**RE: The Wymont  
4315 Wyoming Blvd NE  
Grading and Drainage Plans  
Engineer's Stamp Date: 01/27/22  
Hydrology File: G19D004**

**RE: The Wymont  
4315 Wyoming Blvd NE  
Grading and Drainage Plans (G19D004)**

Per the correspondence dated December 27, 2021, please find the following responses addressing the comments listed below:

RONALD R. BOHANNAN P.E. #7868	THE WYMONT ALBUQUERQUE, NM	DRAWN BY pm
	GRADING AND DRAINAGE PLAN	DATE 11-2-21
	TIERRA WEST, LLC 5571 MIDWAY PARK PL NE ALBUQUERQUE, NEW MEXICO 87109 (505) 858-3100 www.tierrawestllc.com	DRAWING 2021008-GR
		SHEET # GR-1
		JOB # 2021008

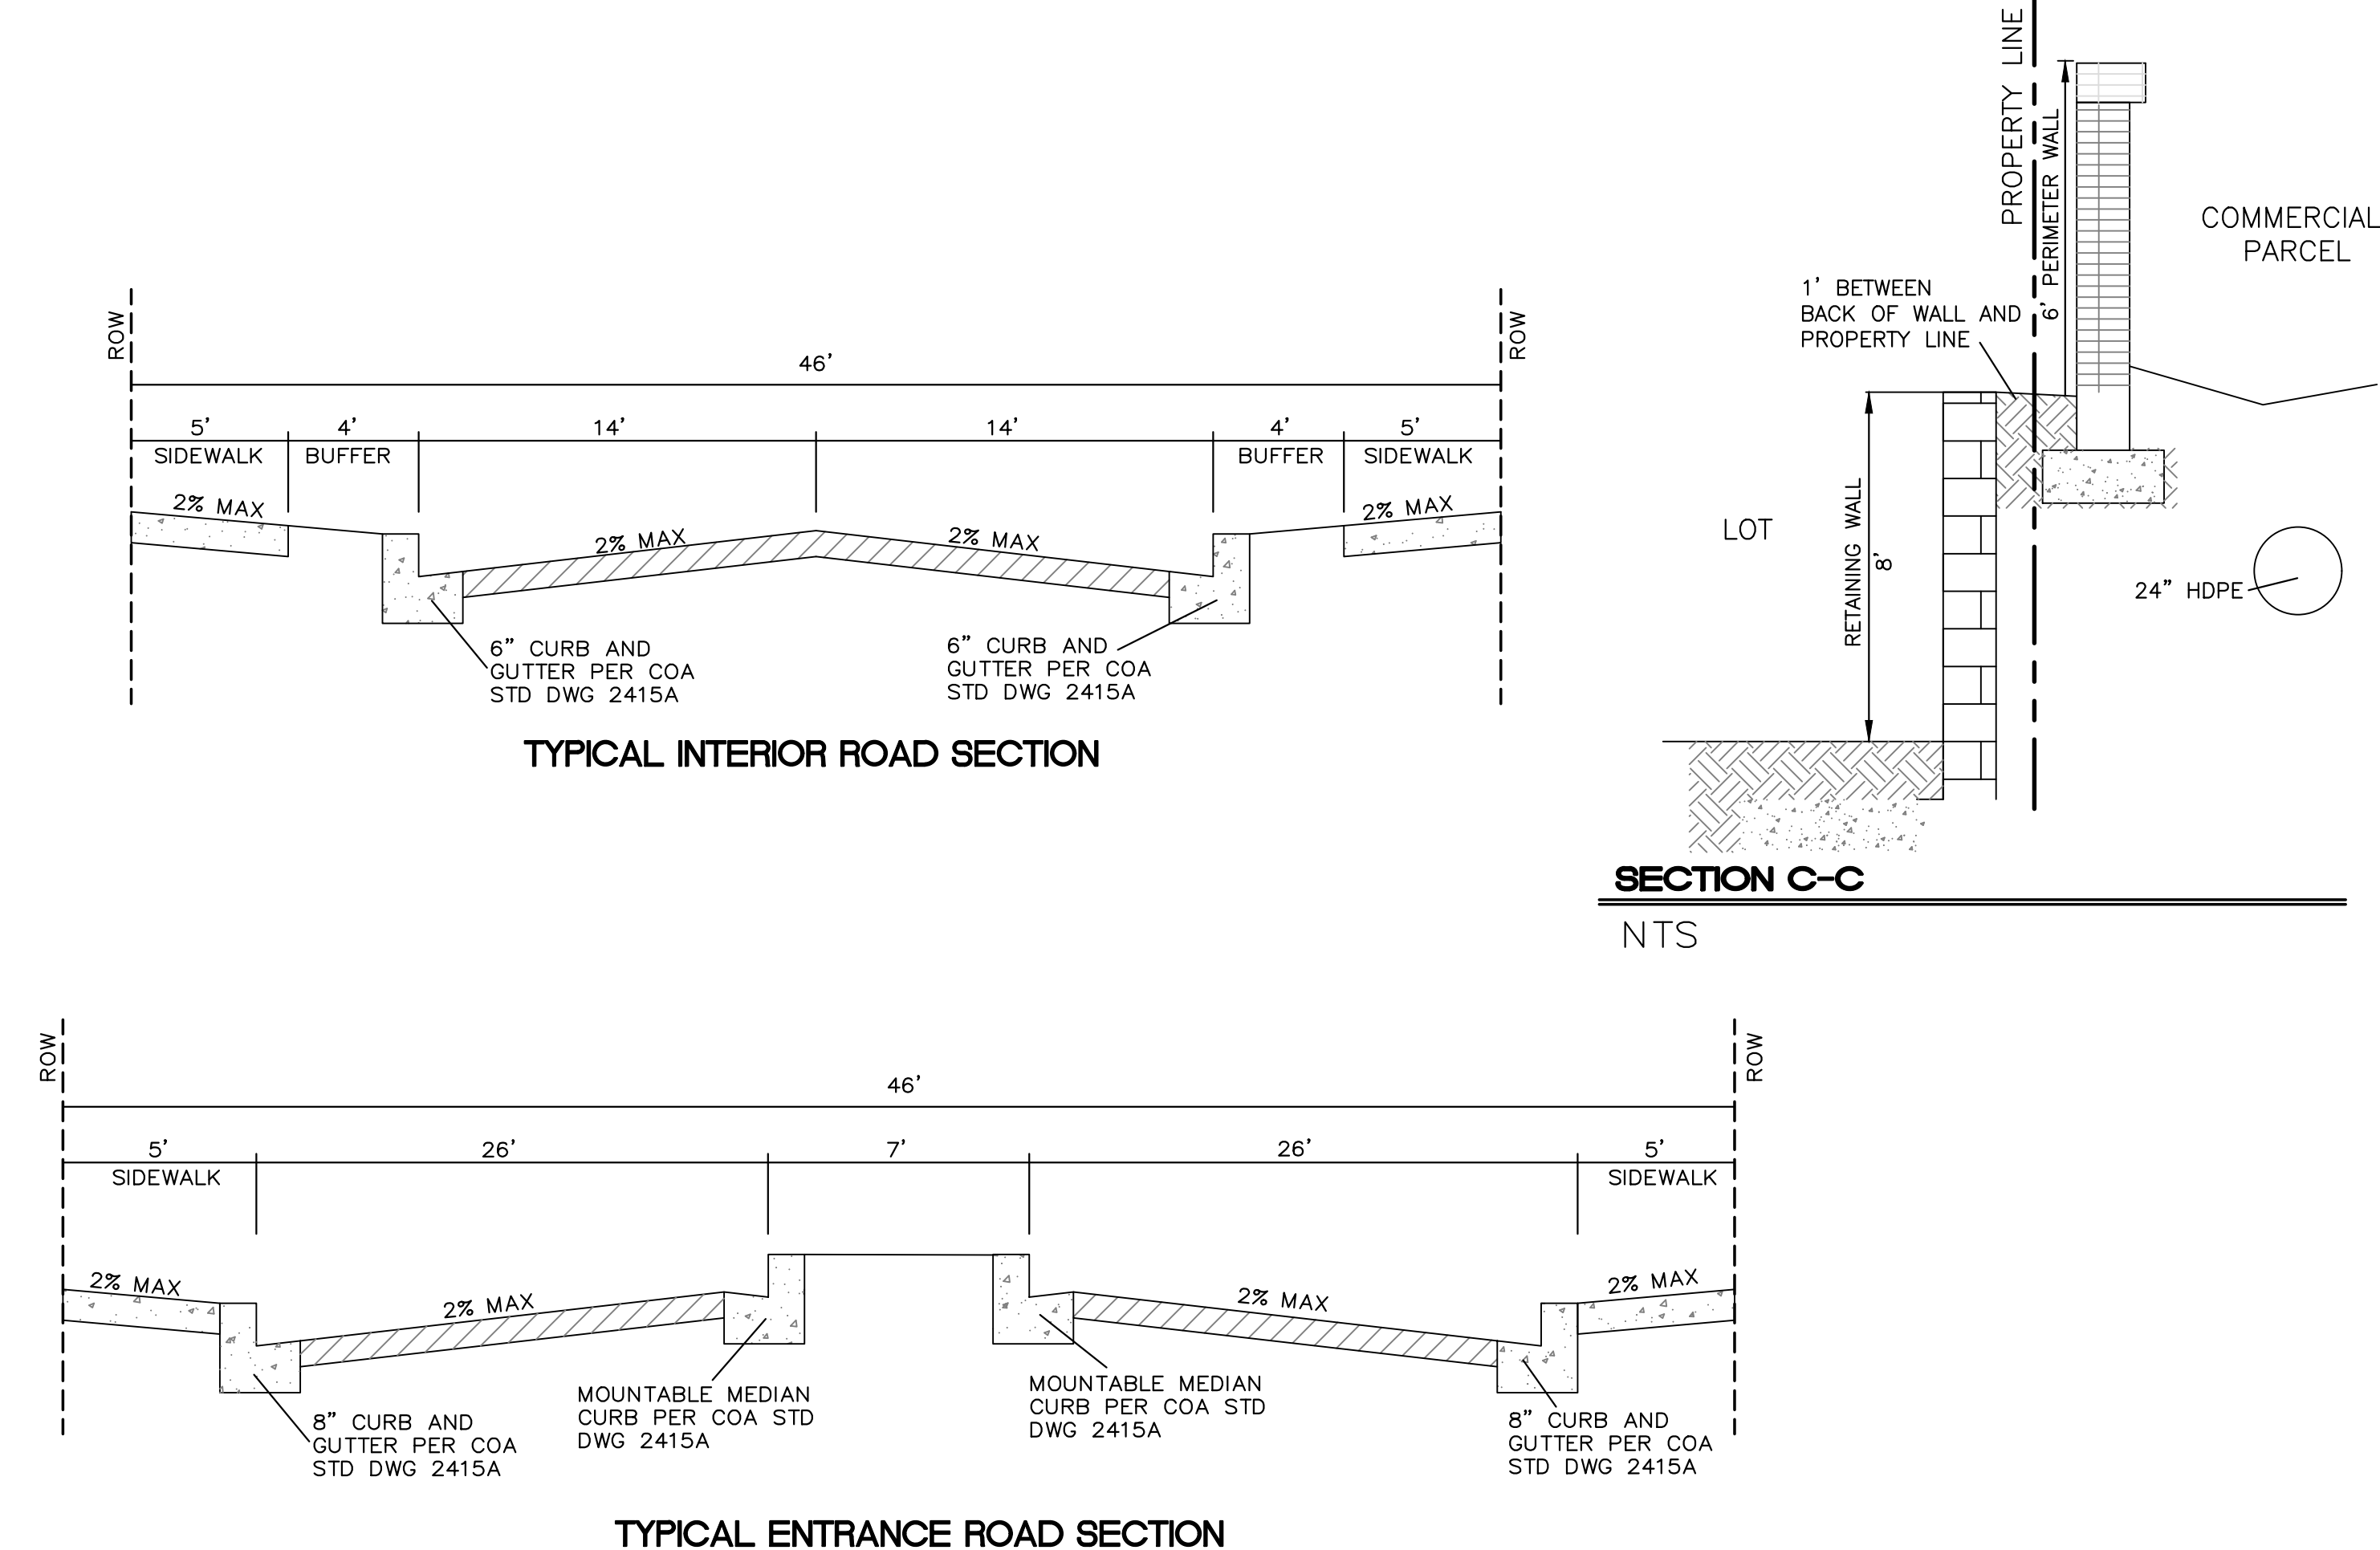
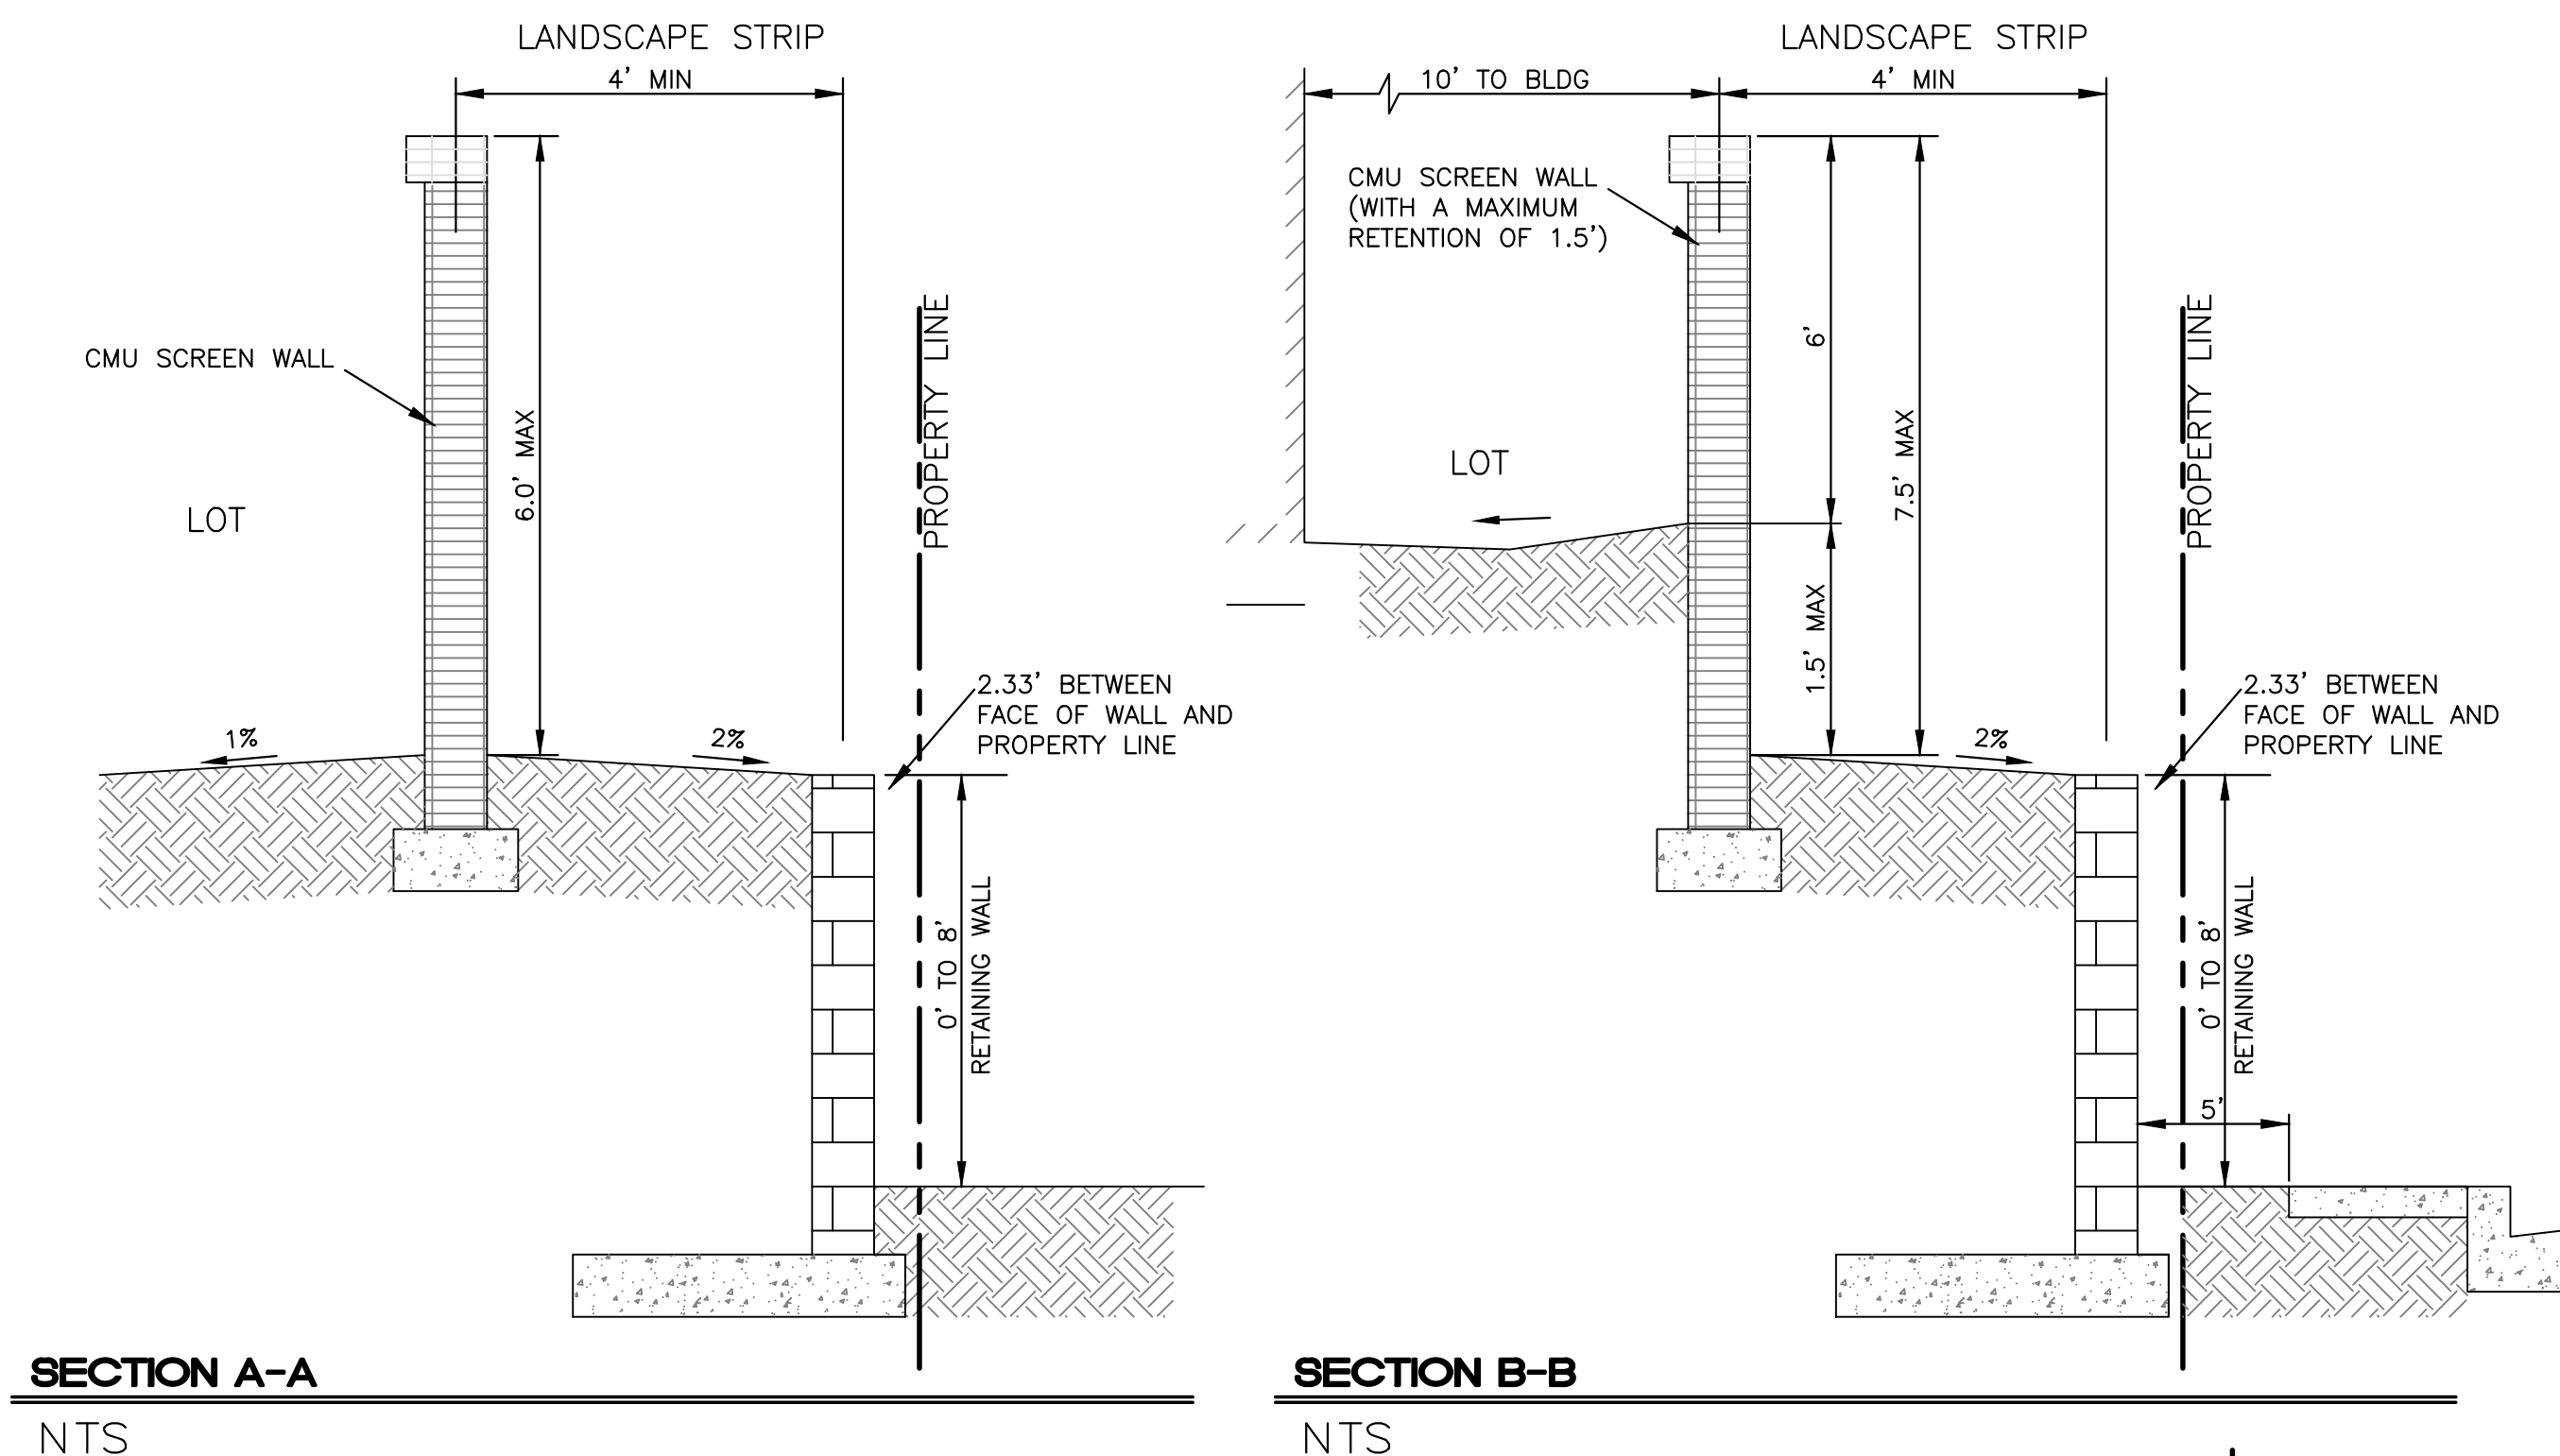
3. GR-1. This is currently very congested and difficult to read. Please, make this sheet just an overall Grading Plan with added pipe sizes, detention pond labeled, proposed contours, and line work with text showing which pipes and grading are to be done under which of the two work orders. **The sheet scale was increased to 1"=30' for better readability.**

4. GR-1. Please add a note, "Side slopes need to be stabilized with Native Grass Seed (per City Spec 1012) with Aggregate Mulch or equal (Must satisfy the "Final Stabilization criteria" CGP 2.2.14.b.)". This is for the water quality pond. **This note was added to the plan**
